PLUMBING APPLICATION

Town or Plantation	PORTLAND
Street Subdivision Lot #	56 COMMERCIAL STREET

From: Suzanne Hunt
To: amcpartland@woodardcurran.com
Date: 9/10/2008 1:51:32 PM
Subject: 46 commercial St.

We are requiring that a self priming floor drain be installed in the men's room portion of this bathroom renovation. This floor area is open and it is reasonable to install a floor drain as required per St. Code. This project is a Renovation of a bathroom per permit # 080716. The floor drain is required to be self priming. thanks, Suzanne

WASTE AND VENT PLAN

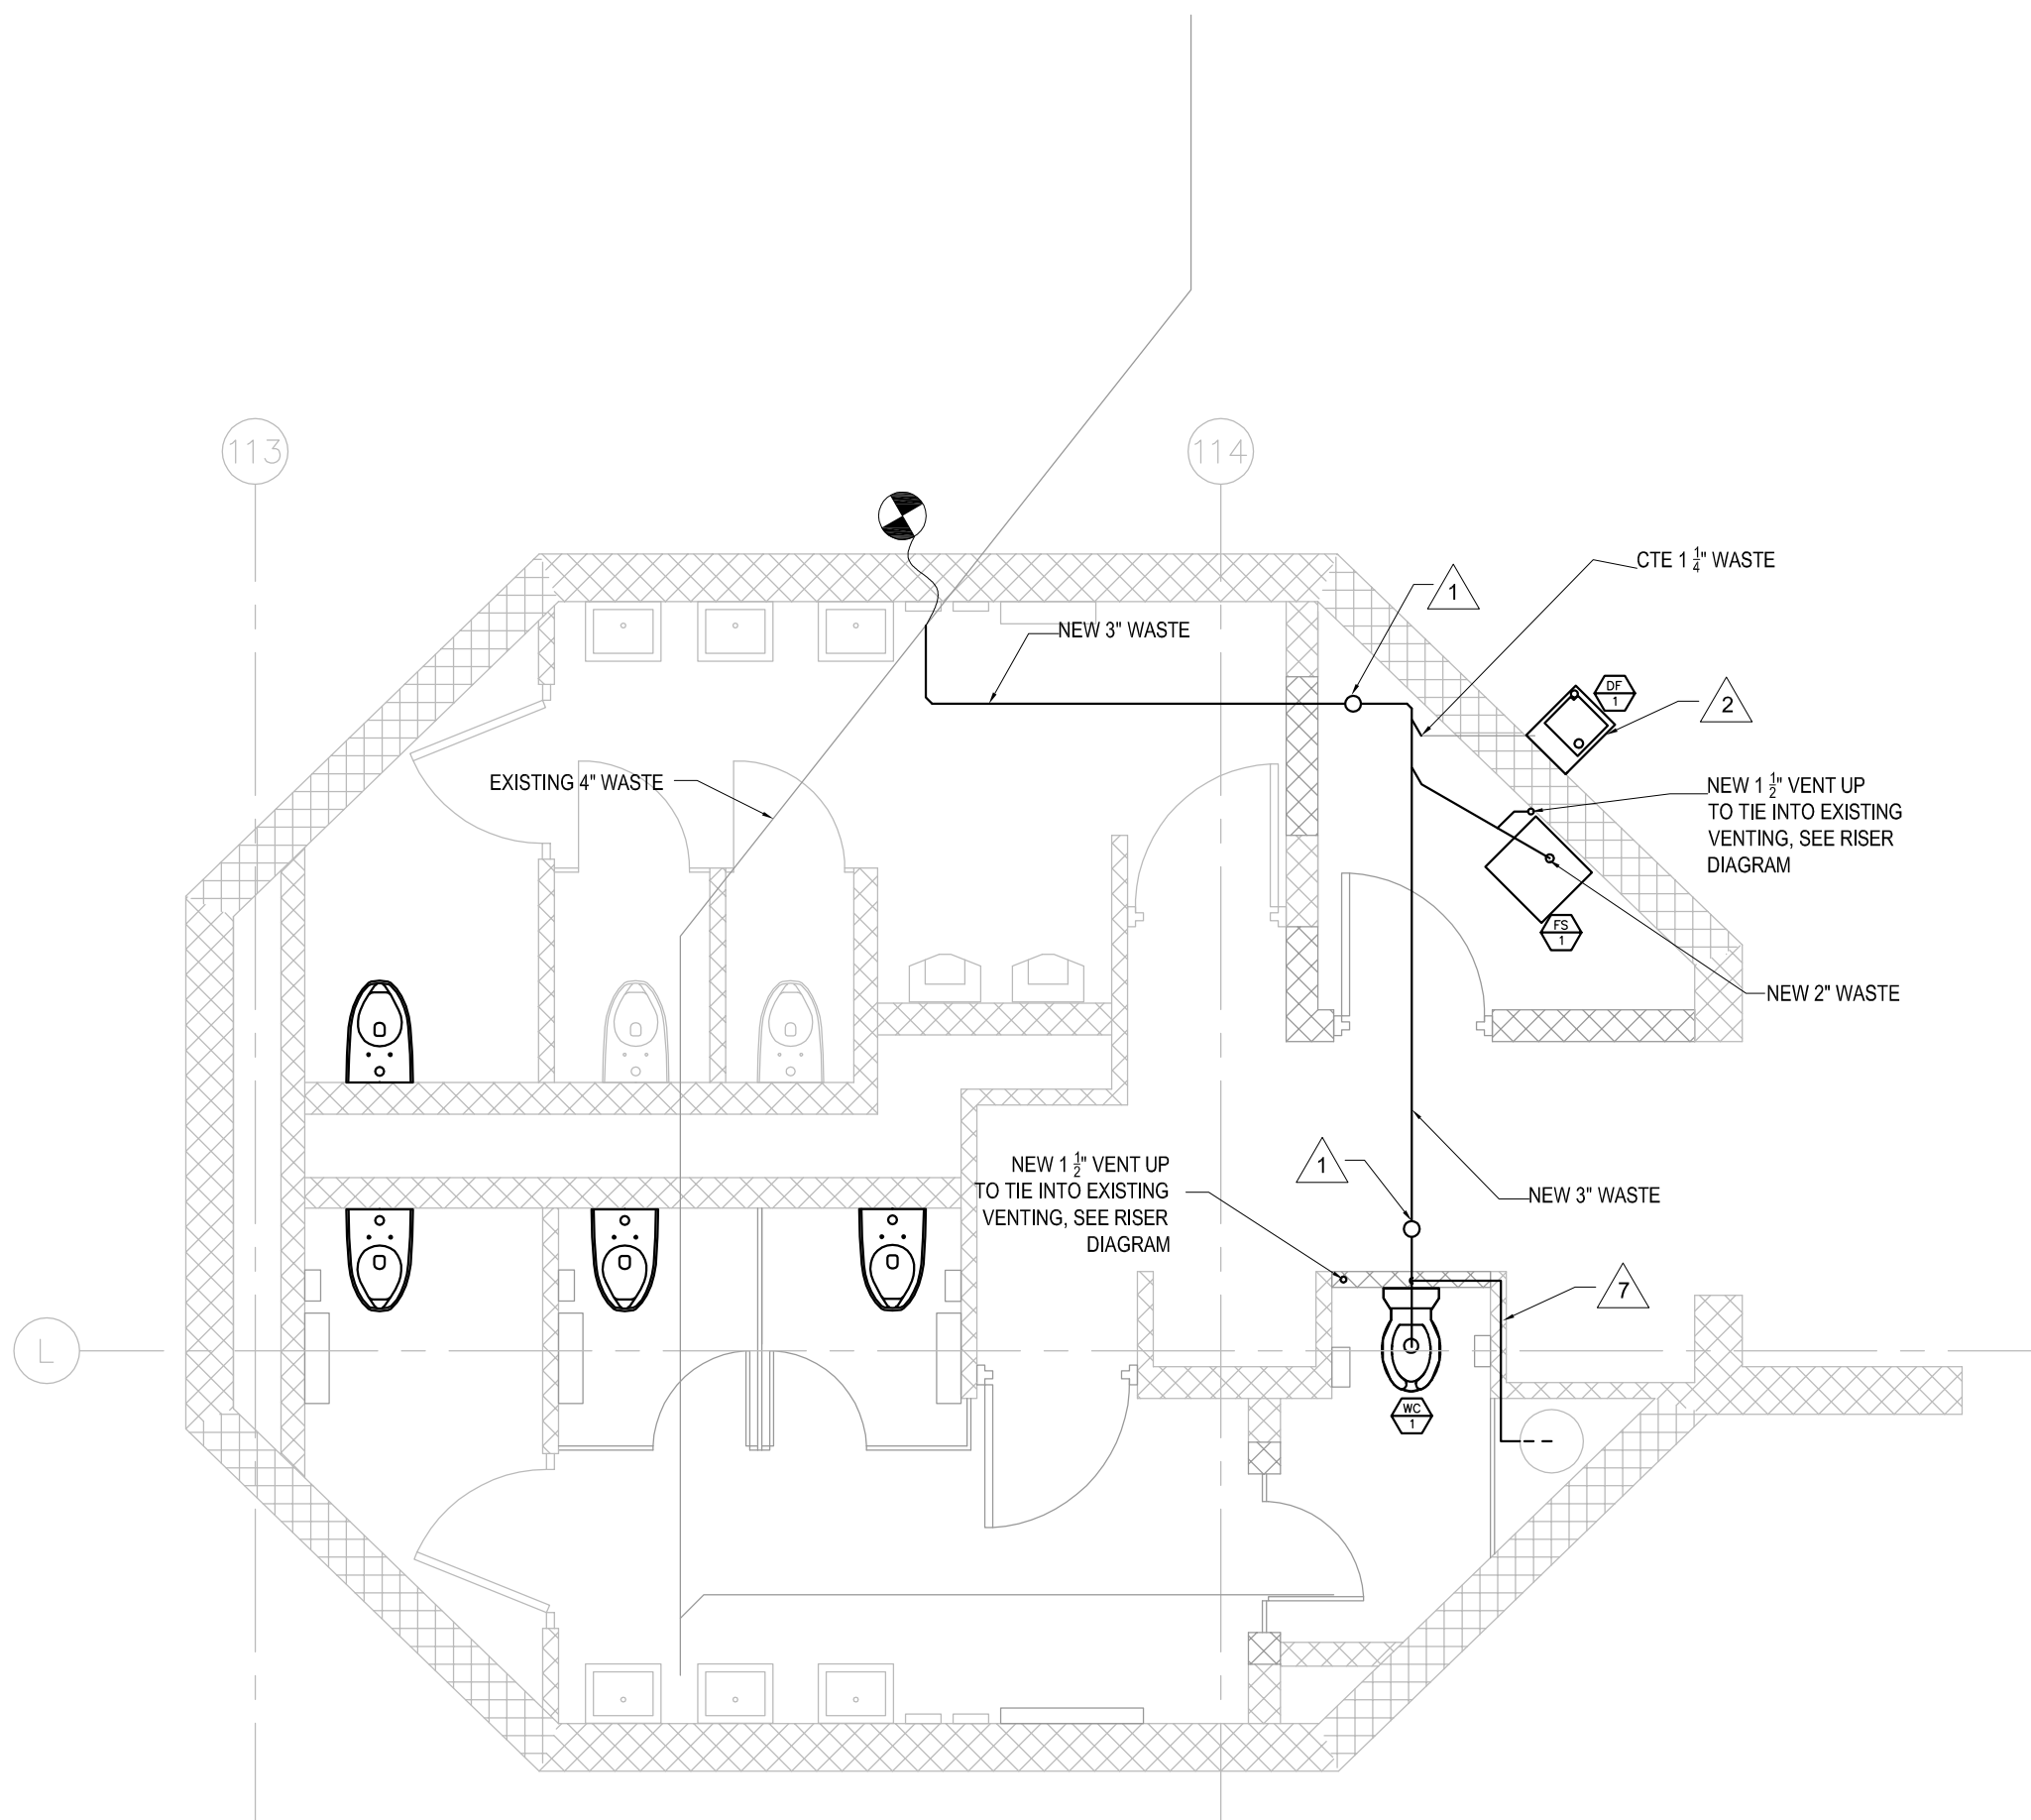
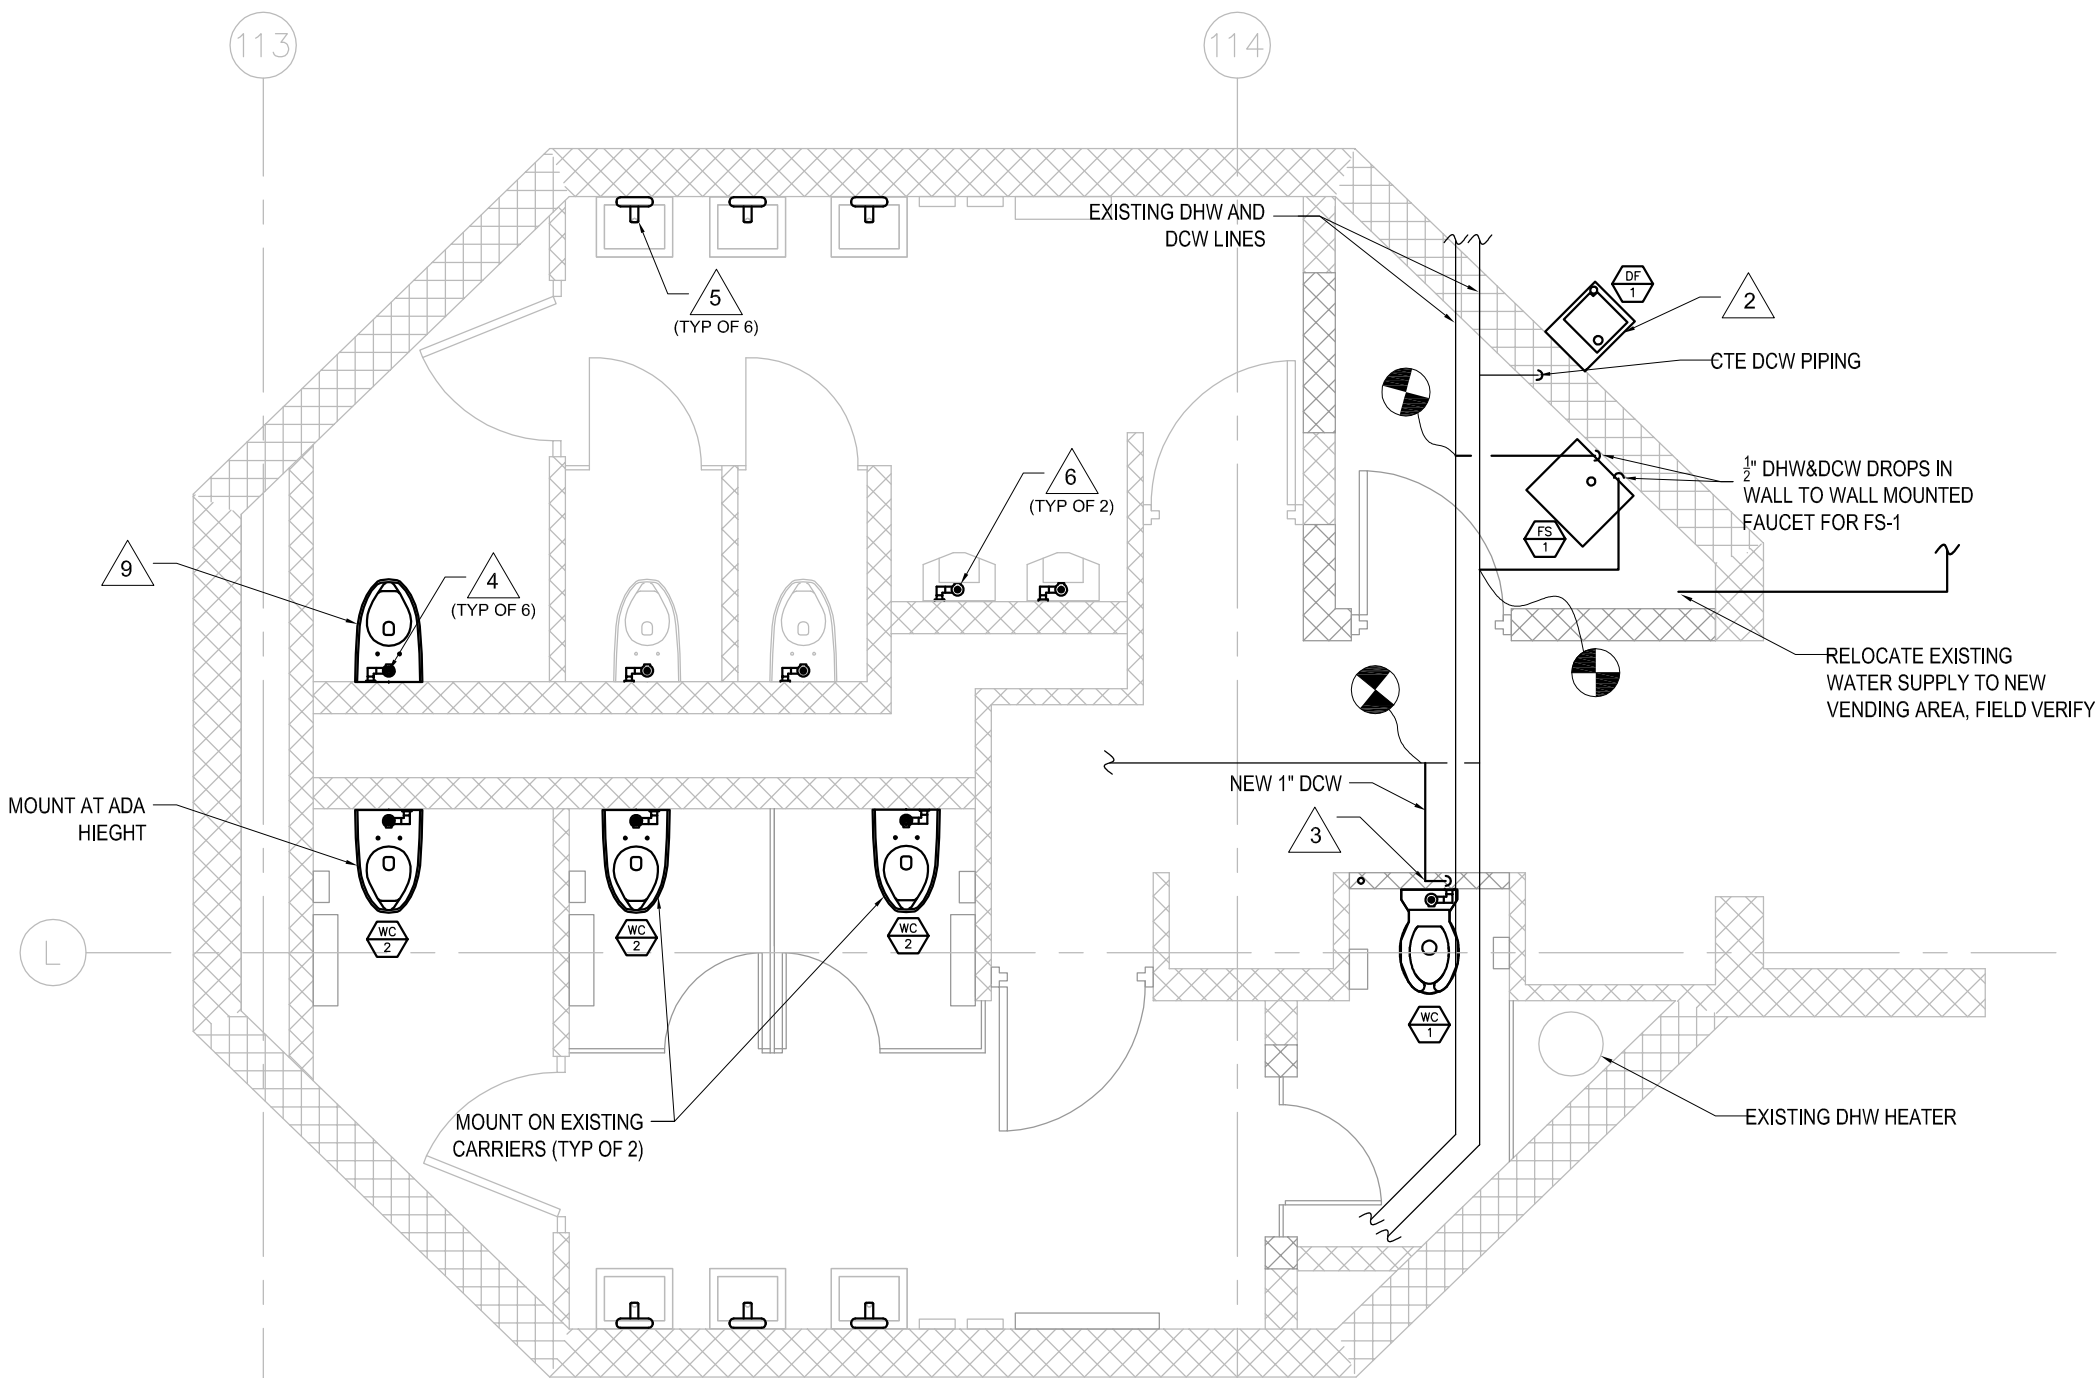
State Plumbing code: 412.2 floor drain required in toilet room with 2 or more water closets.
